MEMORANDUM

Subject: Crawford Apartments
Response to Review Comments Regarding Existing Sidewalk

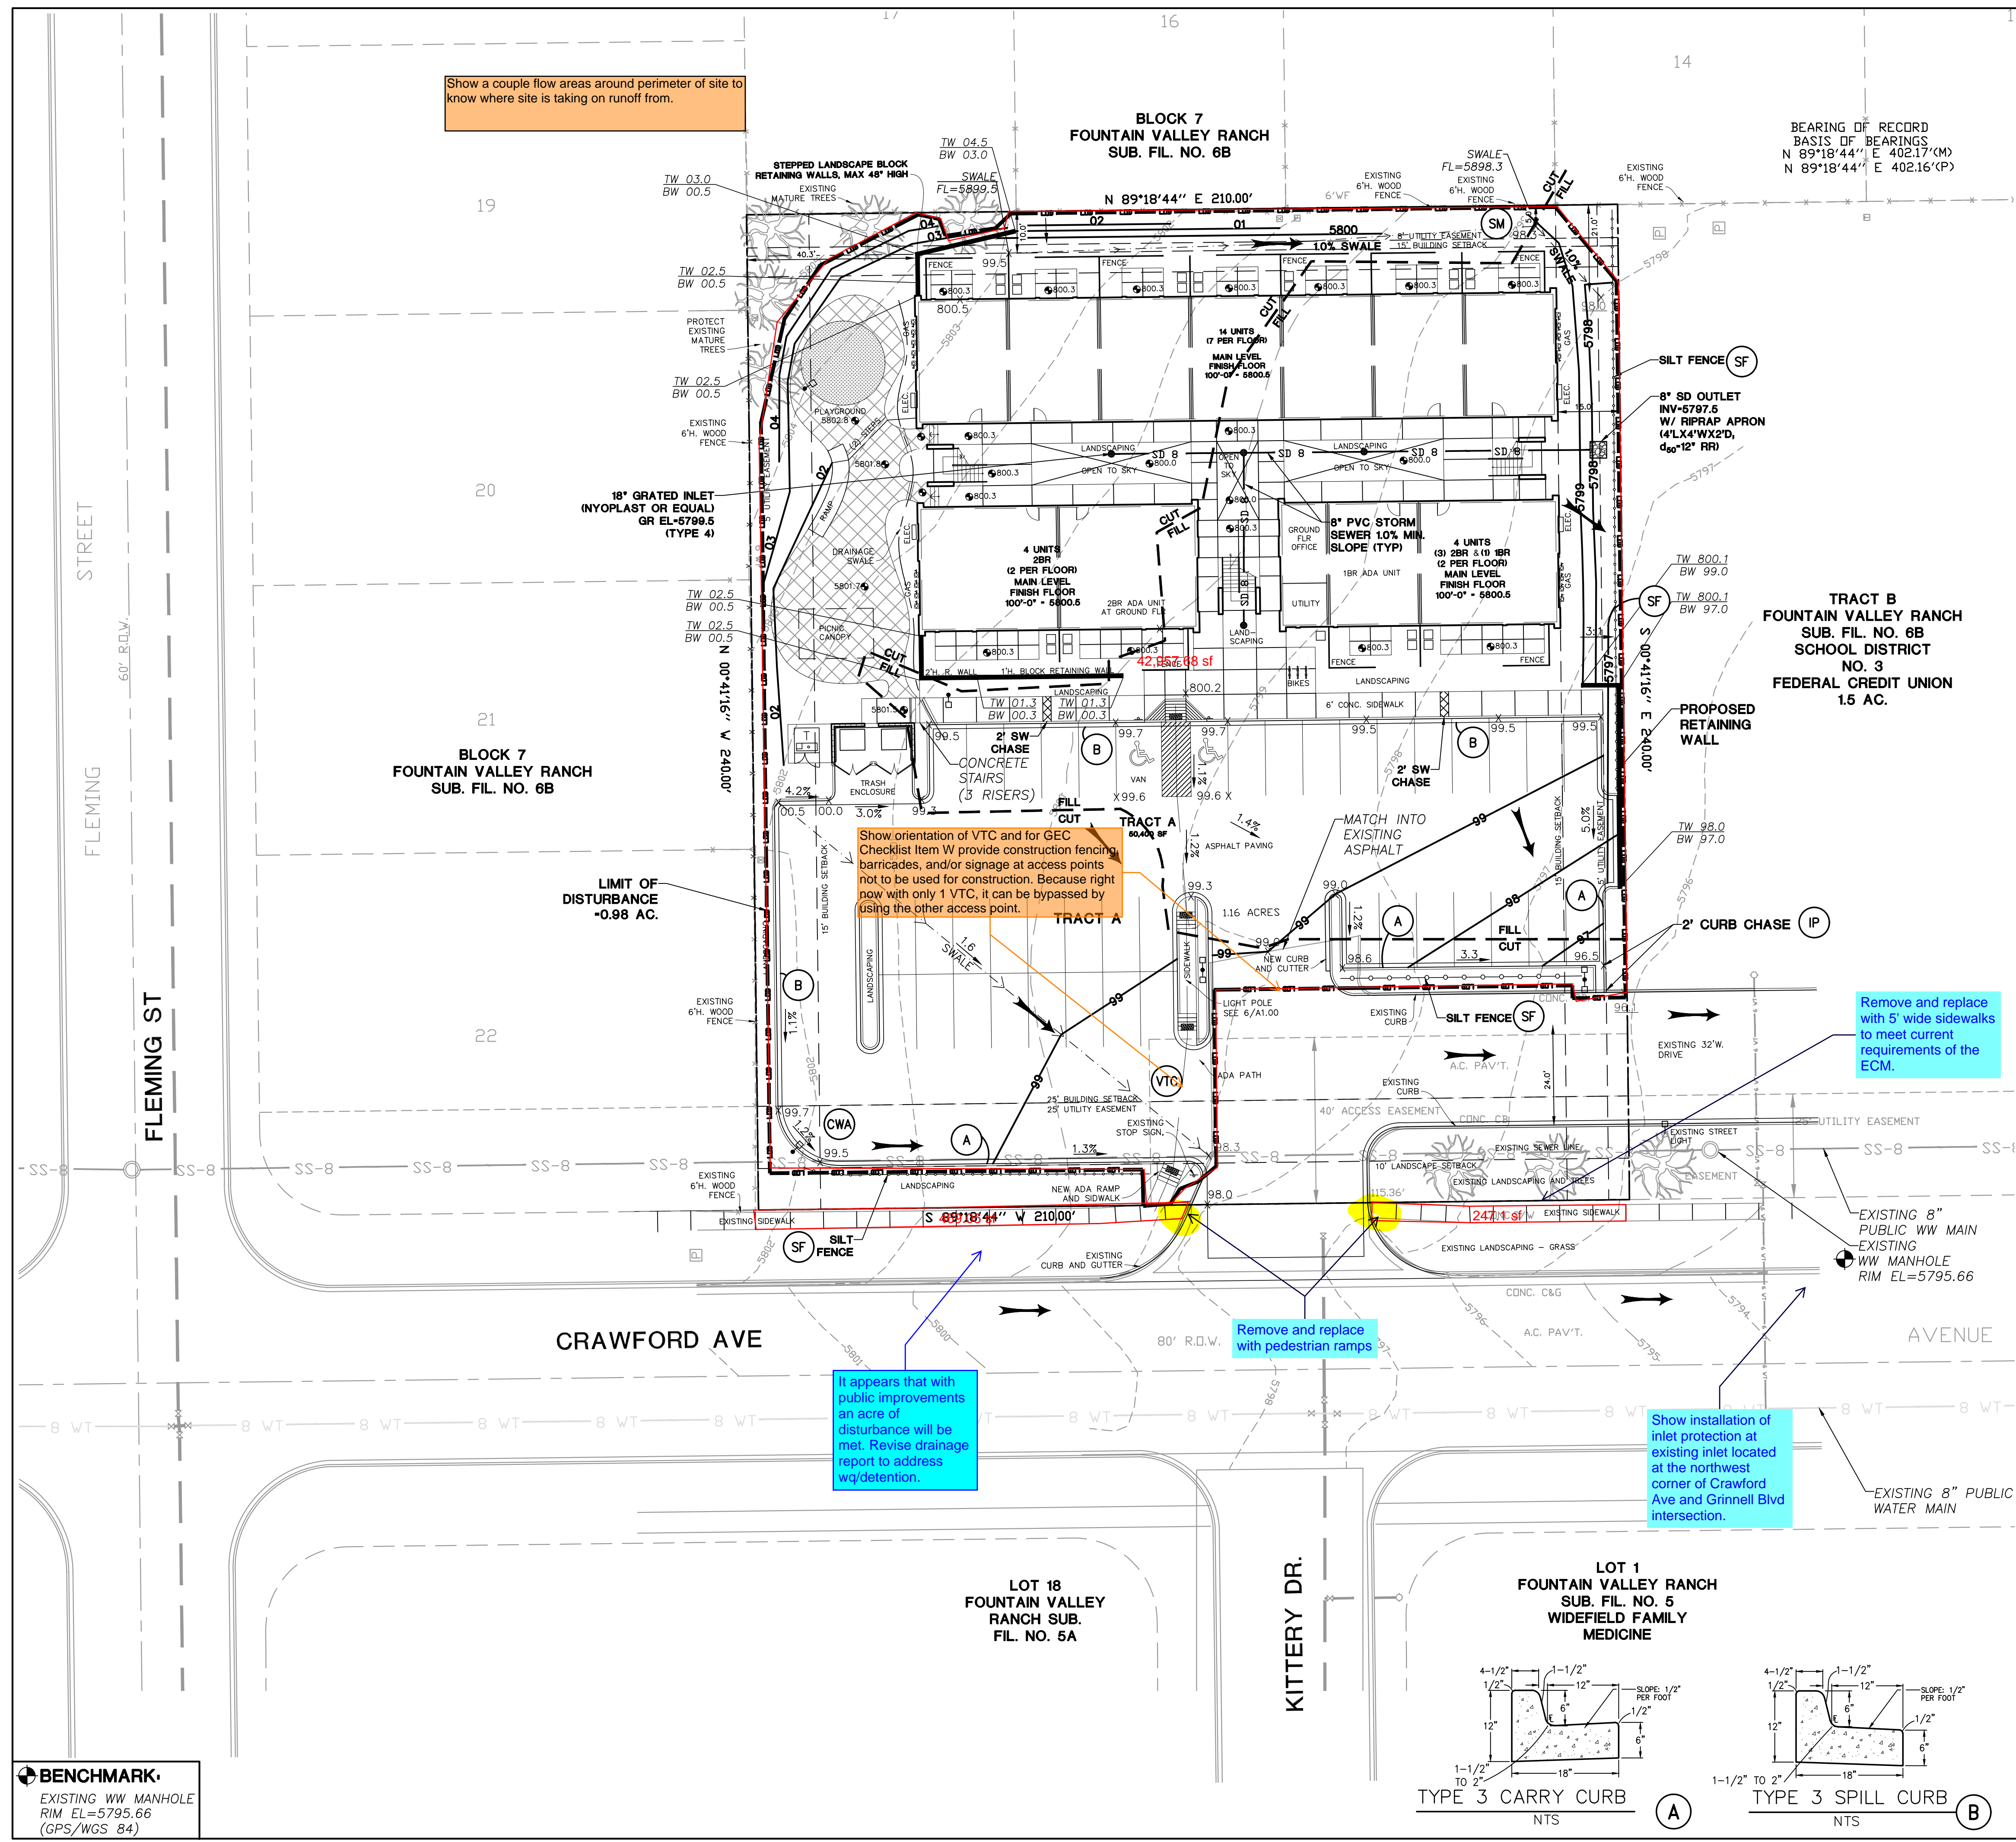
During the initial round of review, there were engineering comments requesting removal and replacement of the existing 4-foot wide sidewalk along the Crawford Avenue frontage of the property. A County Engineering review comment on Sh. C1.1 of the GEC Plans states "Remove and replace with 5' wide sidewalks to meet current requirements of the ECM." A County Engineering review comment on Sh. D1 of the Drainage Report states "Revise sidewalk to meet current criteria per ECM Chapter 6. Sidewalk should be a minimum of 4' wide."

Based on our recent site visit, the County has completed a sidewalk improvement project along Crawford Avenue which included construction of new pedestrian ramps on each side of the existing site access drive. The public sidewalk has been constructed with a minimum width of 4 feet, with appropriate widened passing areas in accordance with ECM Section 6.3.1. As such, we have now noted the sidewalk and pedestrian ramps as existing conditions to remain in place.
